From: Housing Manager DAU <Manager.DAU@npws.gov.ie>
Sent: Monday 21 November 2022 14:49
To: SIDS <sids@pleanala.ie>
Cc: Sarah Caulfield <s.caulfield@pleanala.ie>
Subject: 177AE South Dublin Street Regeneration, Co Monaghan (ABP- JA18.314501-22)

Our Ref: 177AE South Dublin Street Regen
(Please quote in all related correspondence)

Referral under Section 177AE of the Planning and Development Act, 2000, (As Amended):

Application by Monaghan County Council for the South Dublin Street and Backlands Regeneration Project at properties at 7- 13 Dublin Street, lands to the rear of 1-9 The Diamond and 1-26 Dublin Street, incorporating sections of the Northern Standard property, the Courthouse car park, Lower Courthouse car park, Castle Road, and N54 Macartan (Broad) Road, Roosky and Tirkeenan, Monaghan Town Centre, Monaghan.

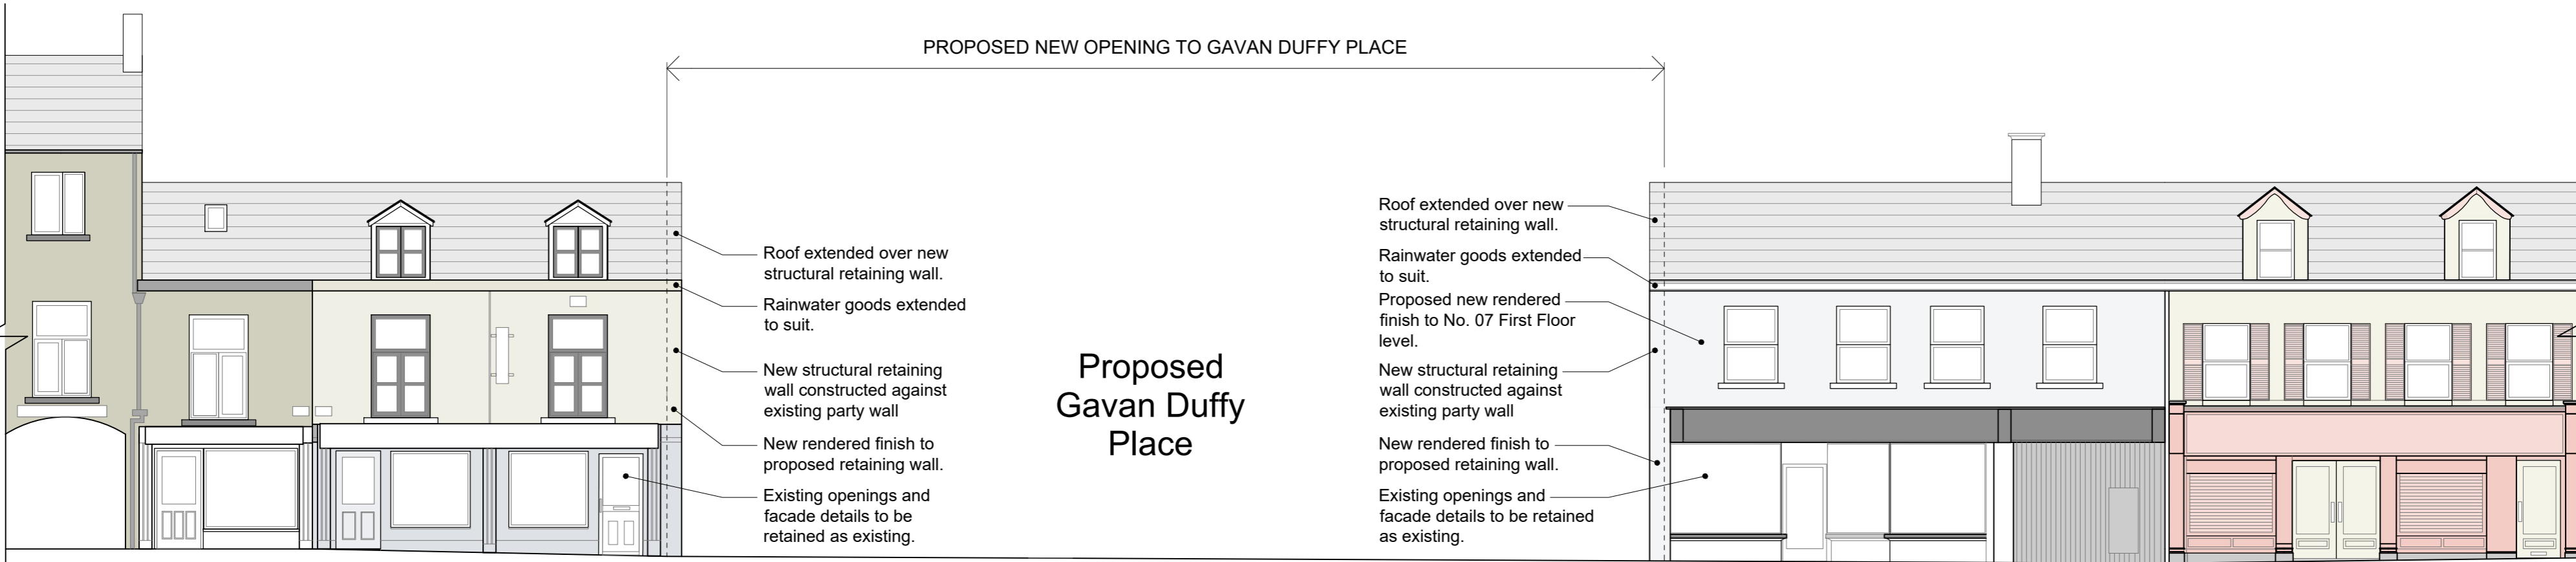
The proposal would remove structures that are within the curtilage of an adjoining protected structure which was allocated significant funding under the Historic Towns Initiative.

Having regard to government's suite of new policy and funding initiatives for town centres, there are some concerns regarding the number of buildings proposed for removal within the town centre of Monaghan. This may require a close look by the planning authority.

Further information could be provided to describe the re-making/repairing of the street –fronted buildings referencing the qualities and characteristics of traditionally constructed buildings of Irish towns. Alternative approaches informed by urban exemplars would enhance the proposal e.g. pedestrian interconnection drawing on the historic precedent of pedestrian archways routes in the town.

The historical urban mapping attached describes the enclosed space and curved line of Dublin Street connecting the central historic spaces of the Diamond and the Old Cross Square. The mapping includes the elements that are part of the setting and character of this place including the scale and rhythm of the street-fronted buildings and arched entrances linking to the long burgage/building plots to the rear. In this context the breaking and opening out of the historic streetscape to a surface car park would not have a wholly positive impact on the cultural significance of the place, the urban form and the coherence of the town plan.
